From: Richard Cowser [REDACTED]
Sent: 02 October 2019 13:49
To: Zac Denton <Zac.Denton@arun.gov.uk>
Cc: Anne Cowser [REDACTED]
Subject: A/110/19/HH

Further to our phone conversation earlier today I note the measurements quoted by the applicants are assumed by you to be correct and that if they are otherwise any planning approval would be invalidated. As I said I have not personally been able to check that a 9m extension would be one metre from our griselinia hedge, which is the boundary between our property and Field House.

PRIVACY SCREEN DETAIL 1/50

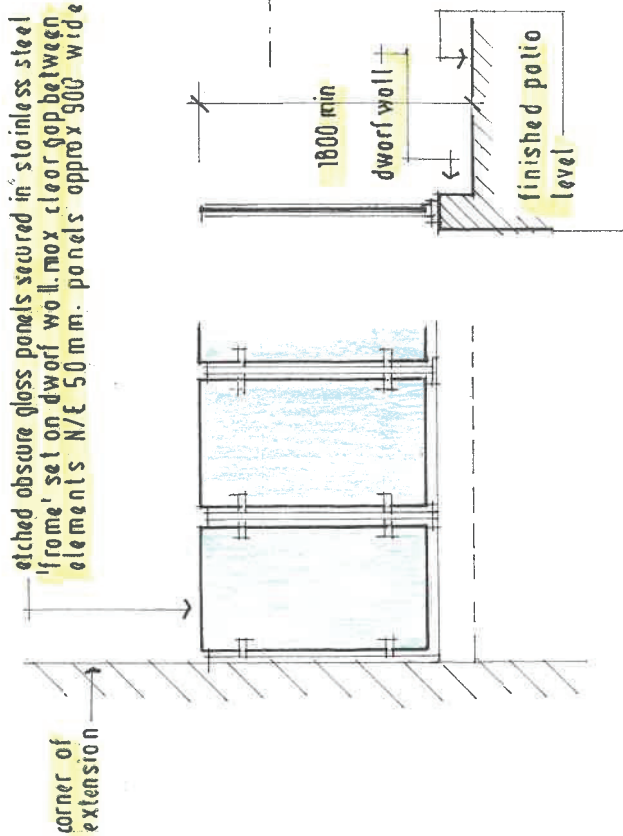
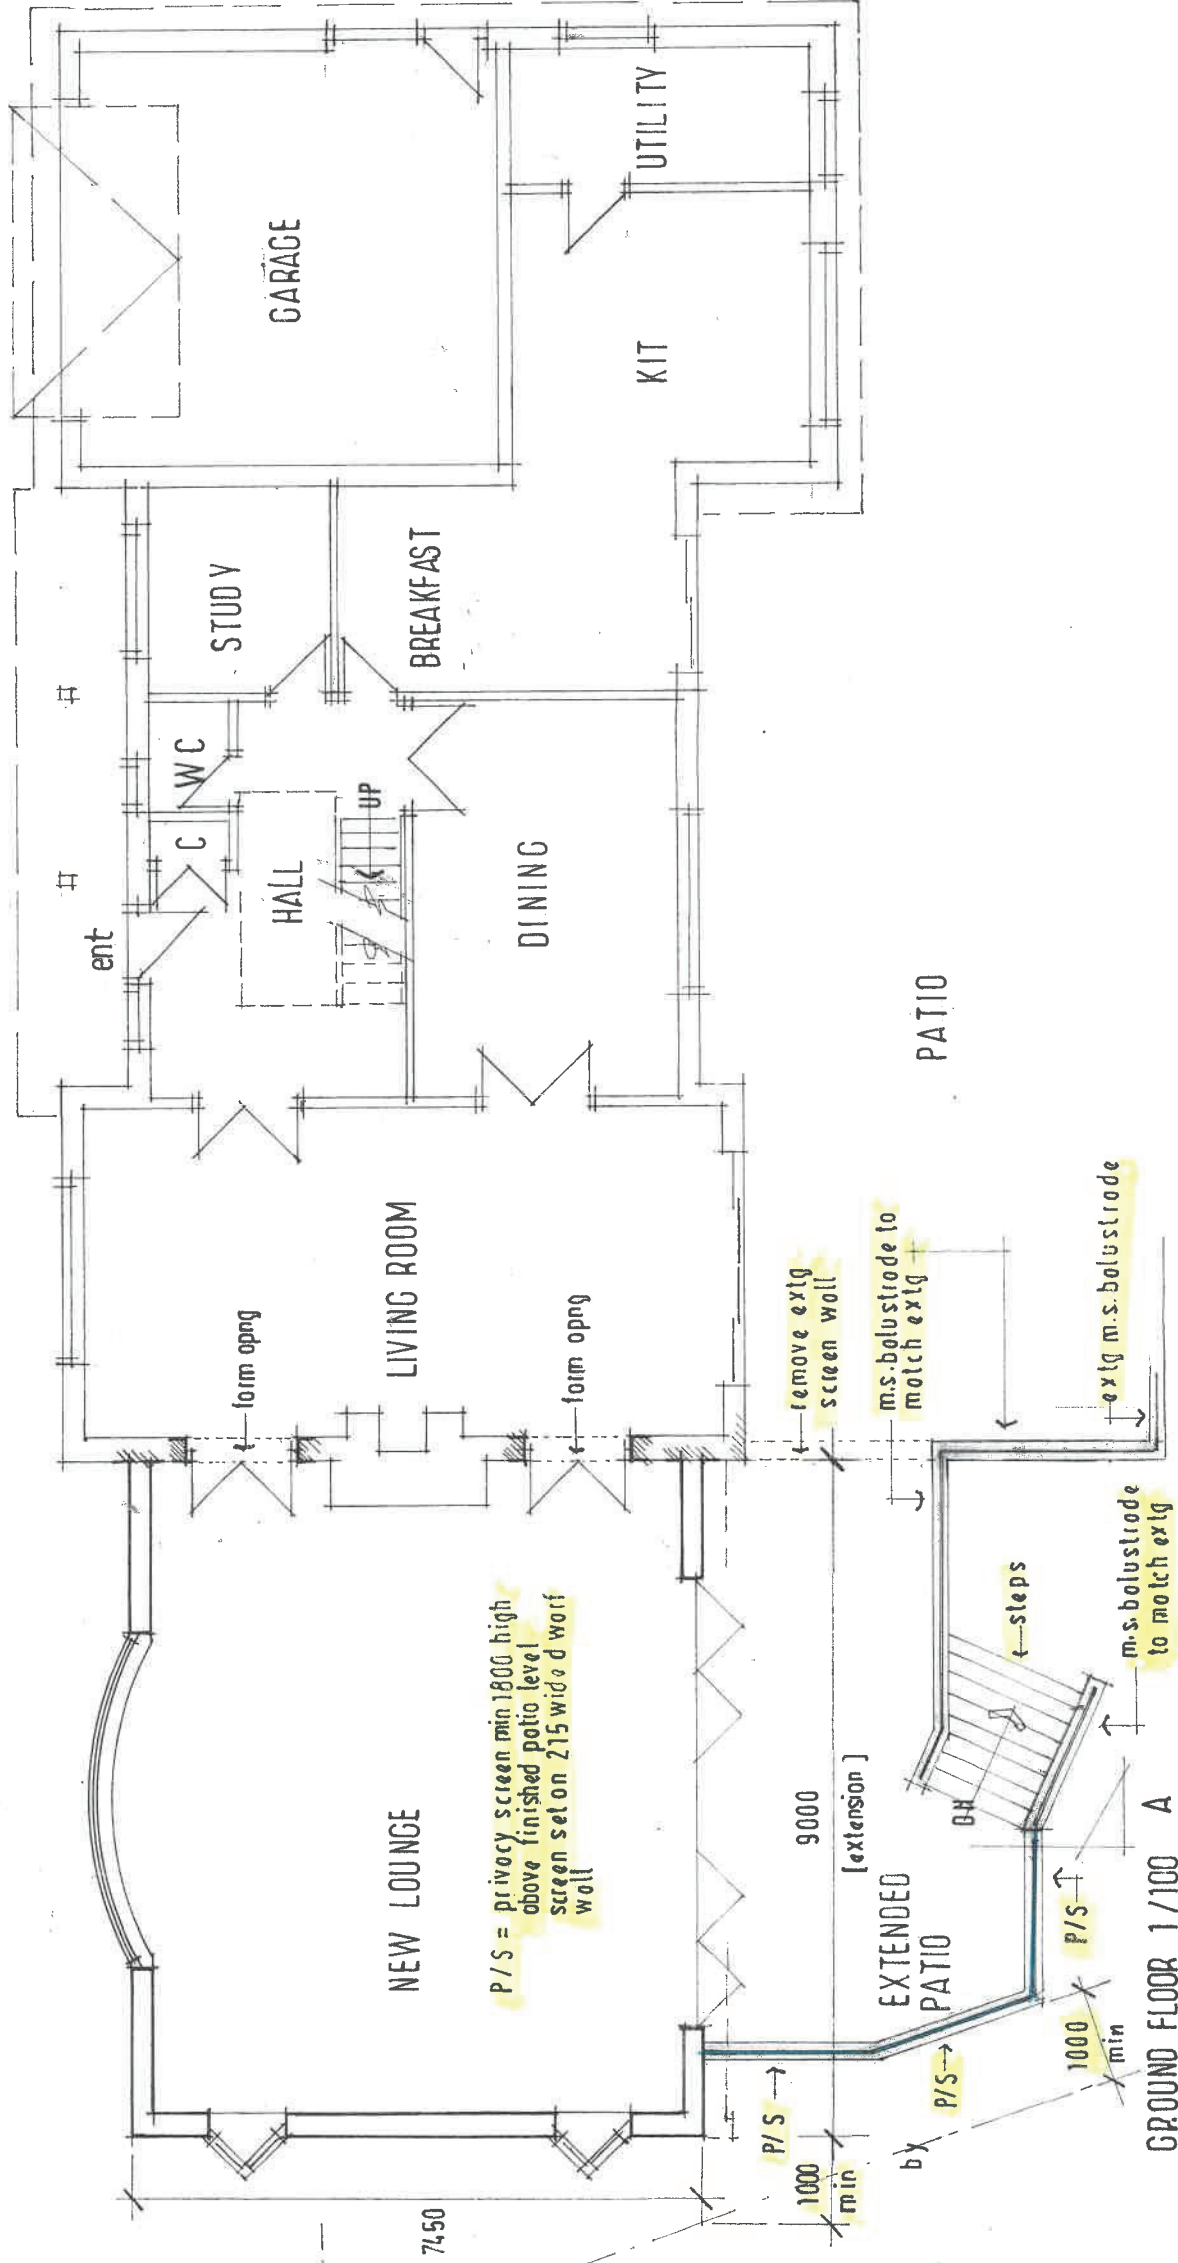
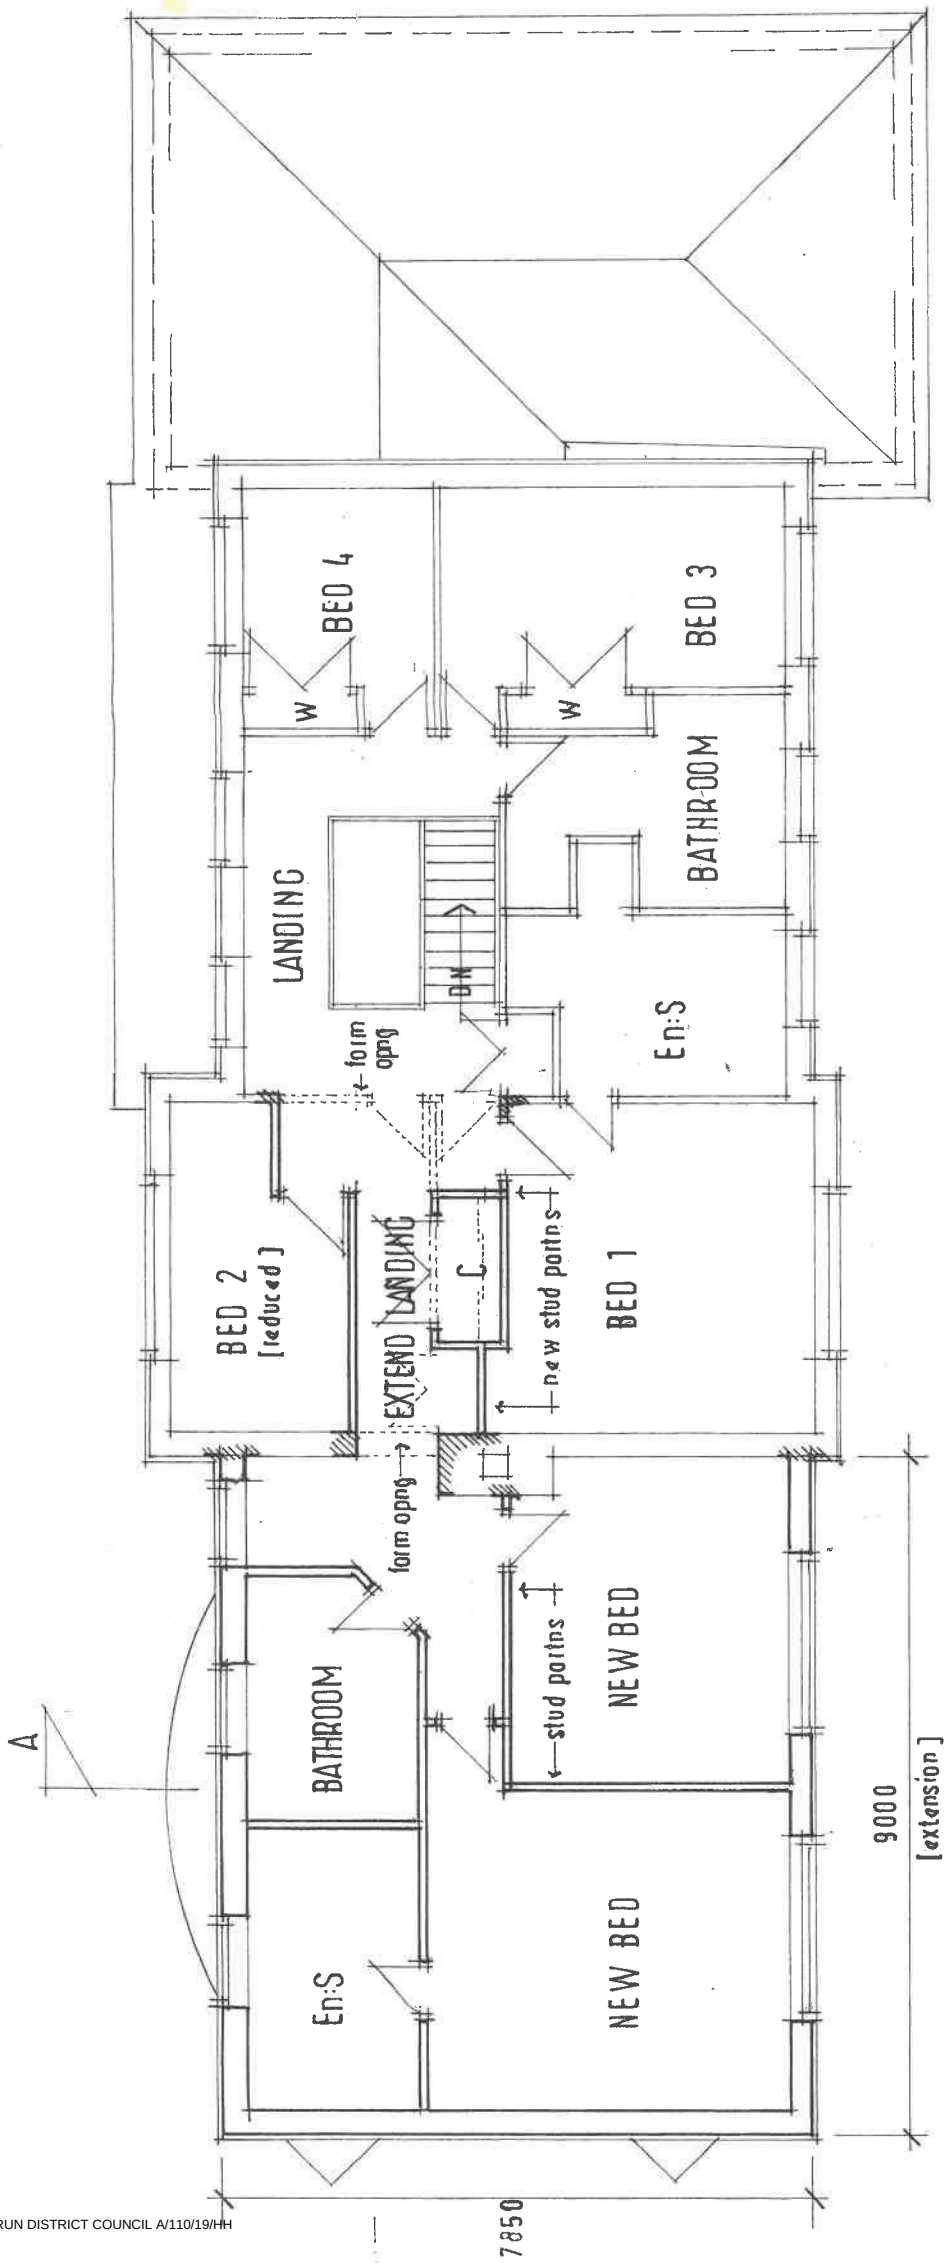
This would result in anyone standing on the south-west corner end of the extended patio appearing to be standing on top of our fence and looking directly down into our garden, not just across it.

Similarly the rear of the two lower ground floor windows on the (western) side of the proposed extension will be above the fence (indeed I think well above the fence) so anyone inside will also look directly down into our garden rather than across it.

Because of the depth of foundations that will be needed we believe that the above condition could only be met if any extension comes no closer than 3 metres to our hedge boundary. We also believe that there should be no window on the side of the lower ground floor that enables those inside to look directly down into our garden (rather than across it), and that there should be no patio extension at all at the back.

Date: APRIL 2019 18/4553/1

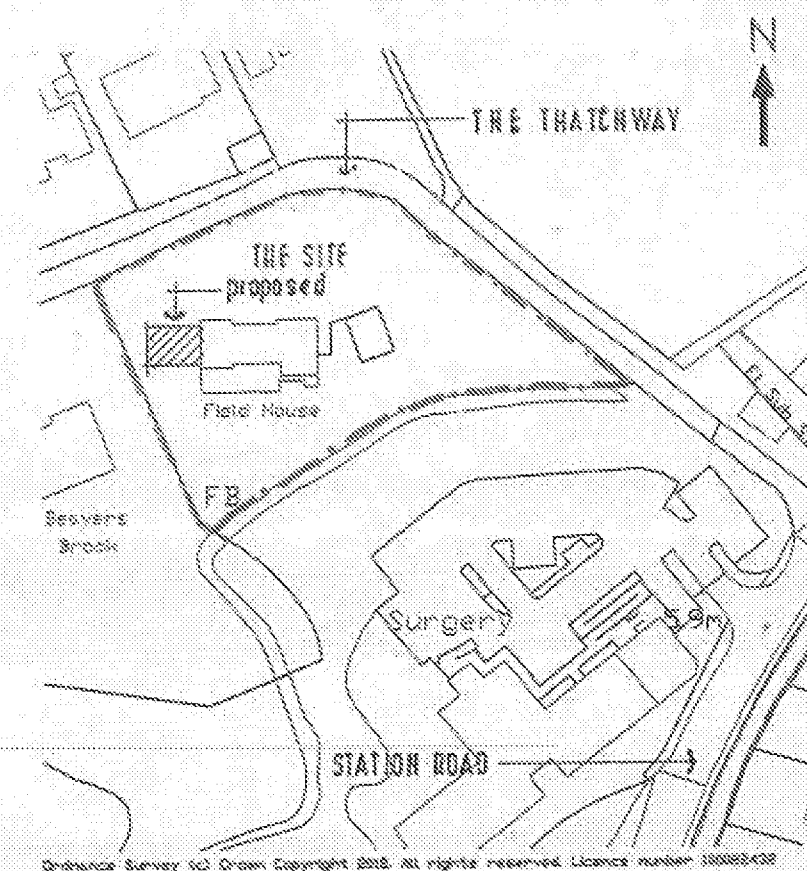
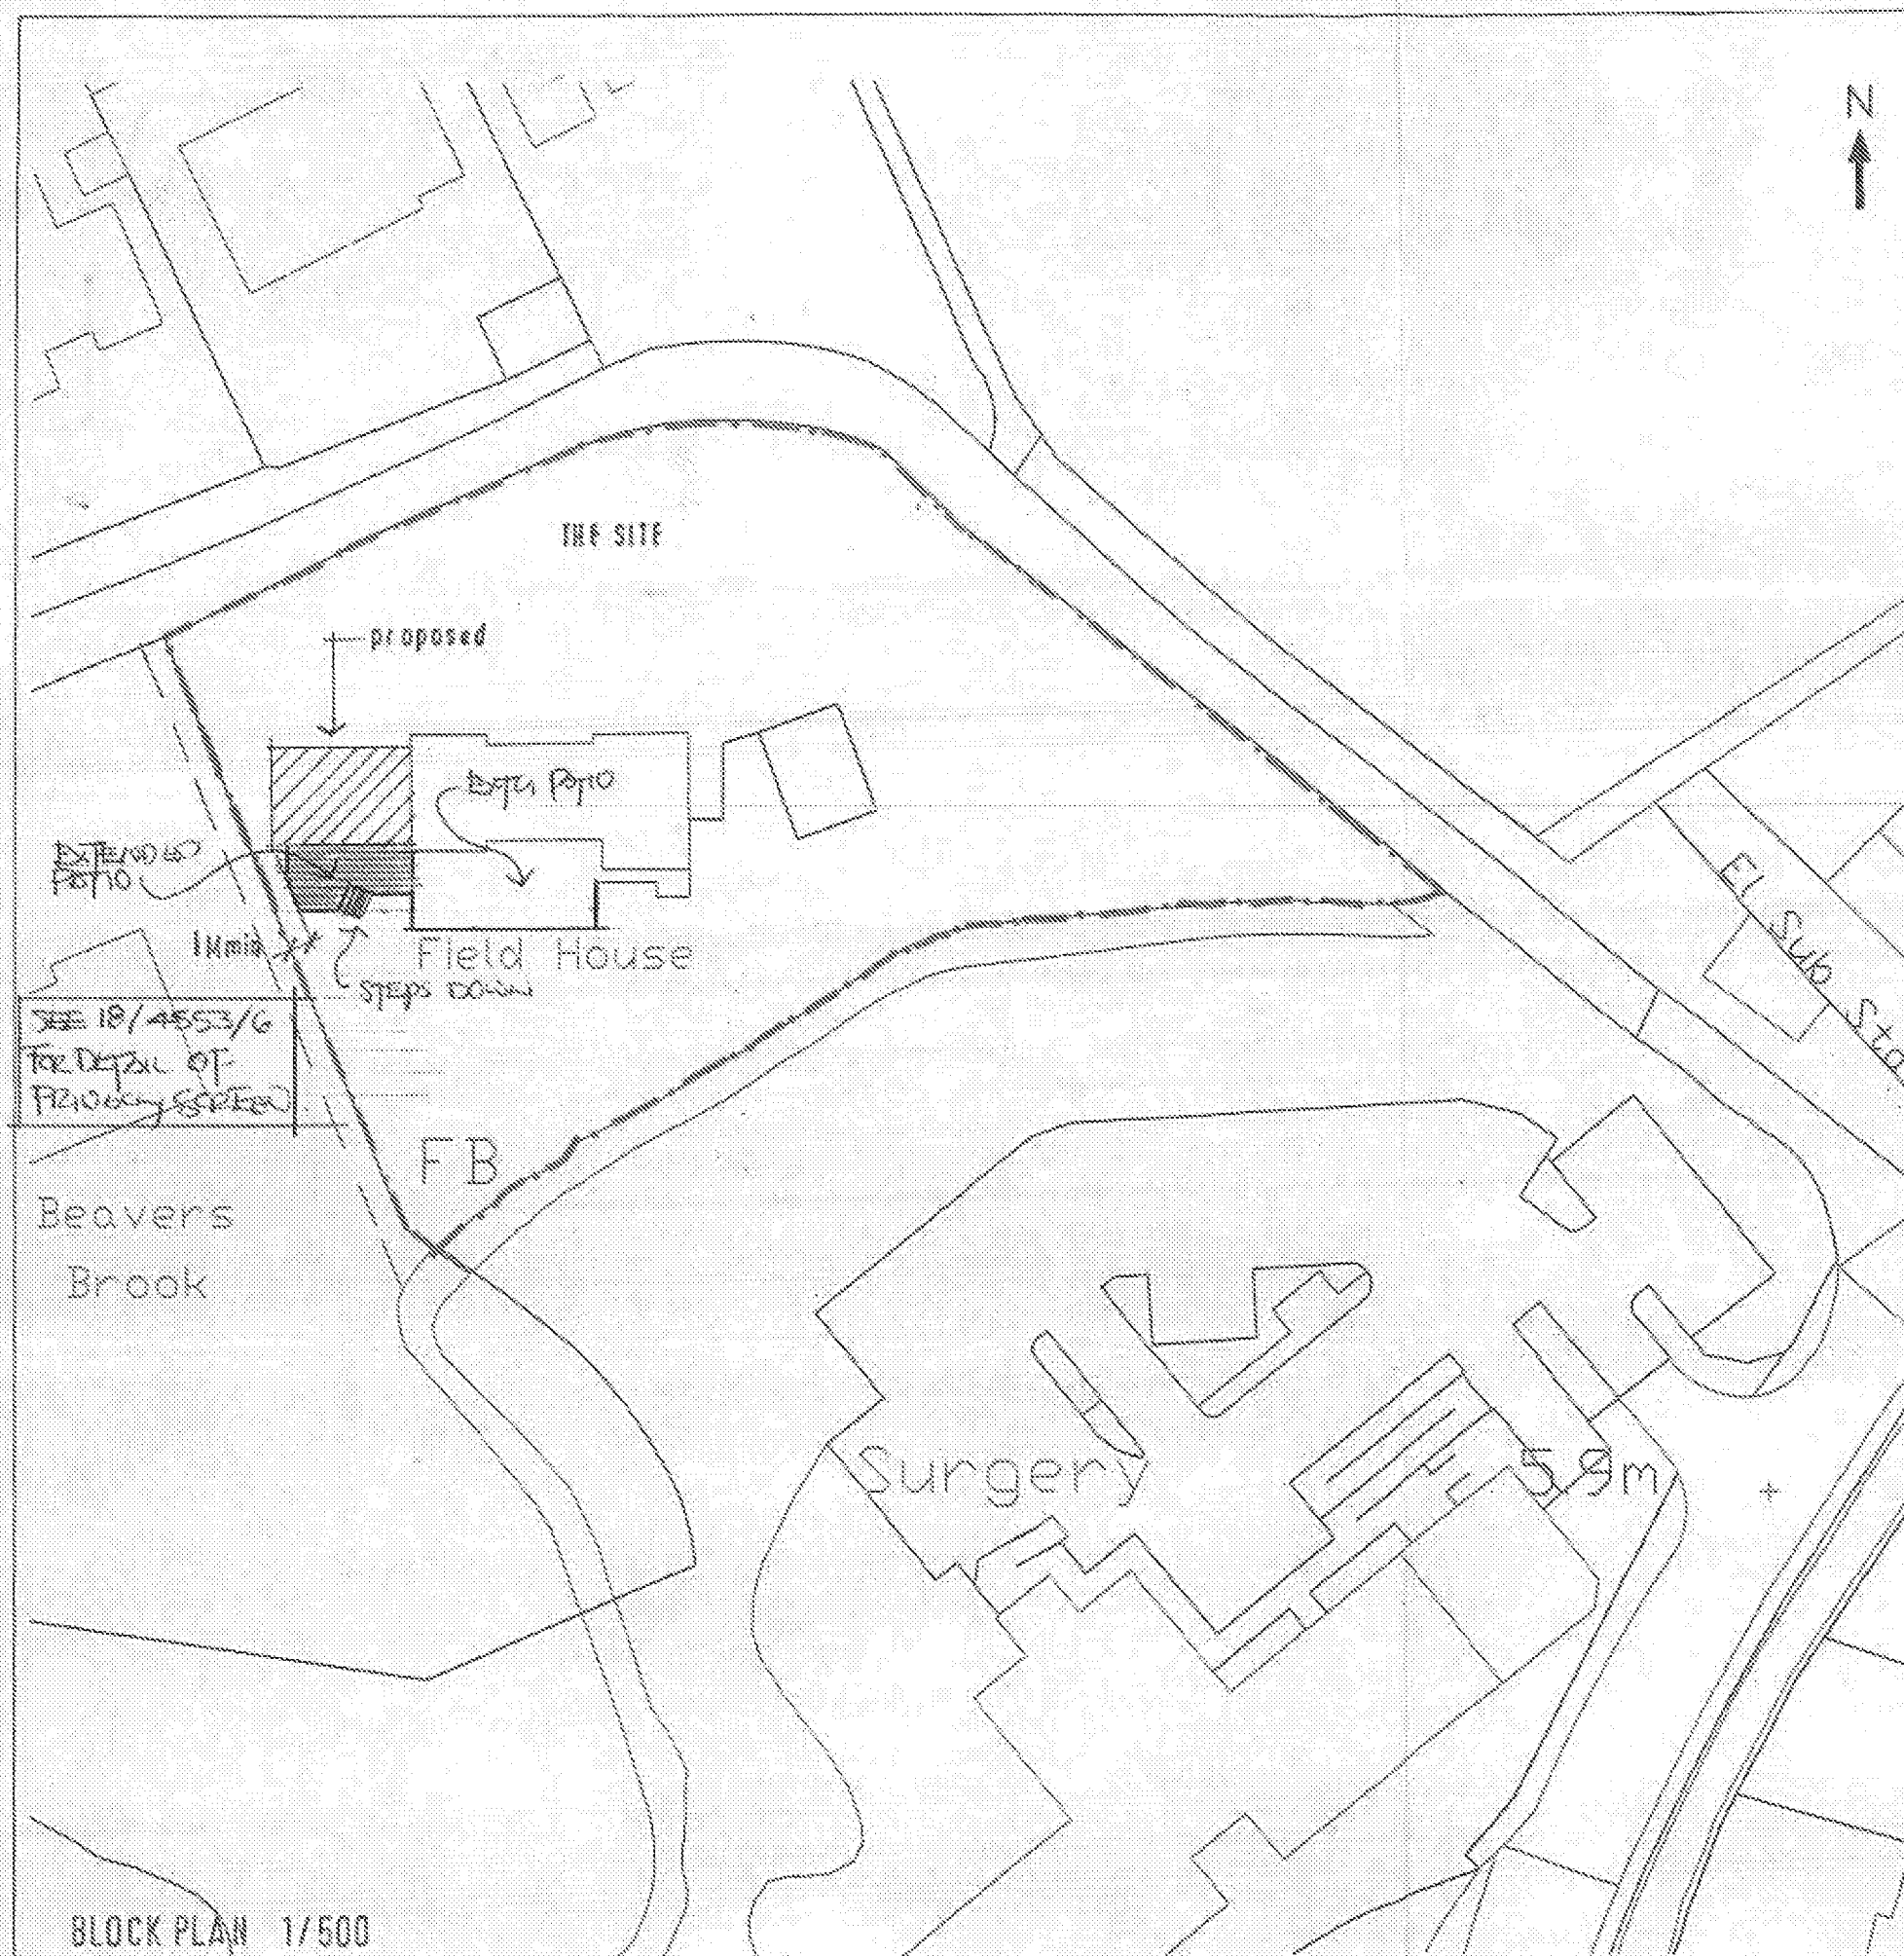
I have taken another look at the Block Plan.

The pink area fails to show any part of the proposed elevated 4.5m-wide patio extension. (The current patio is the roof of the Lower Ground floor of Field House so an extension to it should be shown). Rather the block plan indicates that the current patio will not be extended. Figure 1 of my 25 September letter shows the correct block configuration. The block plan shown with the planning application is totally misleading as all it shows is that one corner of the two story house will be within one metre of our boundary hedge.

The reality is different, since the extended and elevated patio will also largely run one metre from our boundary, and at a height which will mean that **the base of the patio is level with the top of our fence**. Imagine the current patio, shown in the photo below, which is at the moment some 9 metres away from our fence, coming right up to this fence, and running for a length of 4.5 m along the top of the fence.
